COUNTY OF HARNETT RESIDENTIAL LAND USE APPLICATION  
Central Permitting 108 E. Front Street, Lillington, NC 27546 Phone: (910) 893-7525 Fax: (910) 893-2793 www.harnett.org

PROPERTY LOCATION: Subdivision: Woodshire PH 5 Lot #: 174 Lot Size: 348

SILVERADO HOMES, LLC.  
 THE CAMBRIDGE  
 LOT # 174 WOODSHIRE  
 SCALE: 1"=40'

Re: Status of Improvement Permit Application **Woodshire**  
#08-5-19567 Lt 173  
#08-5-19568 Lt 174

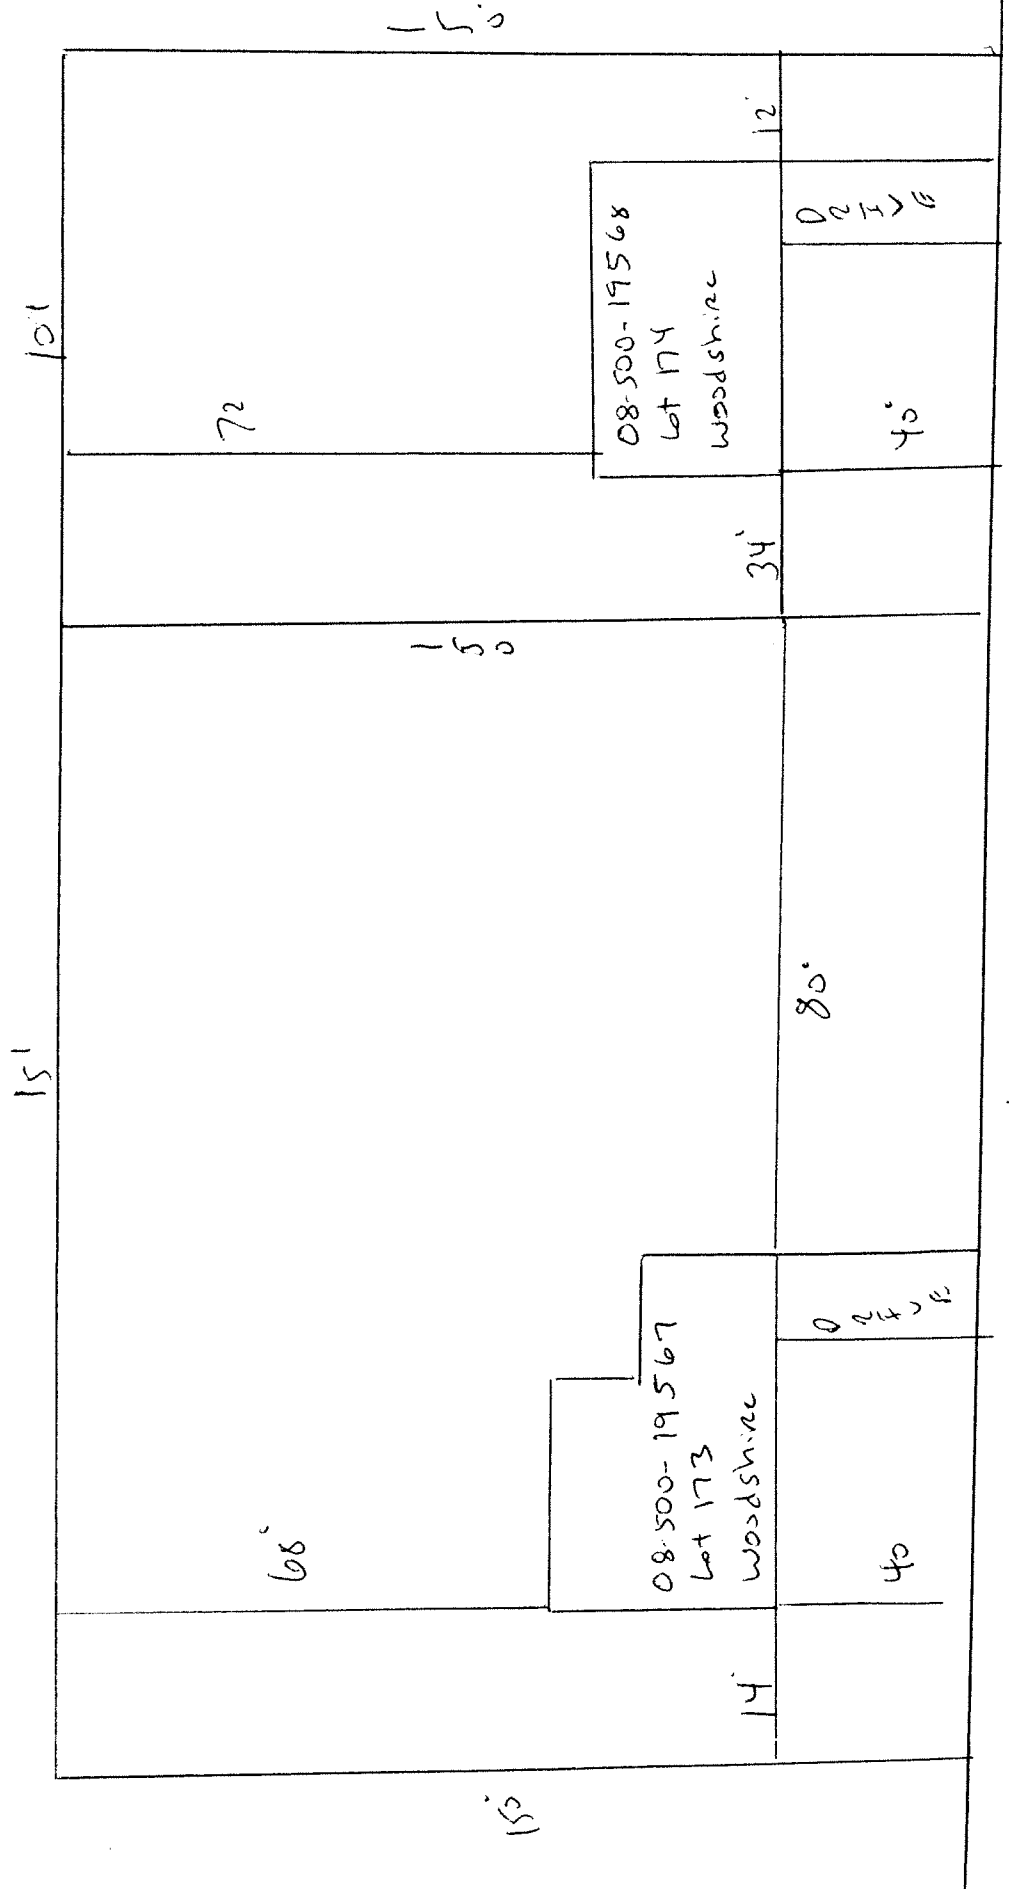
- 1. Property lines/corners not marked or labeled
- 2. House corners not marked or labeled
- 3. Directions not clear to property
- 4. Property needs brush or vegetation removed
- 5. Backhoe pits required
- 6. Other – Make the following changes in house locations and, submit new plot plans to Central Permitting. (See the attached)
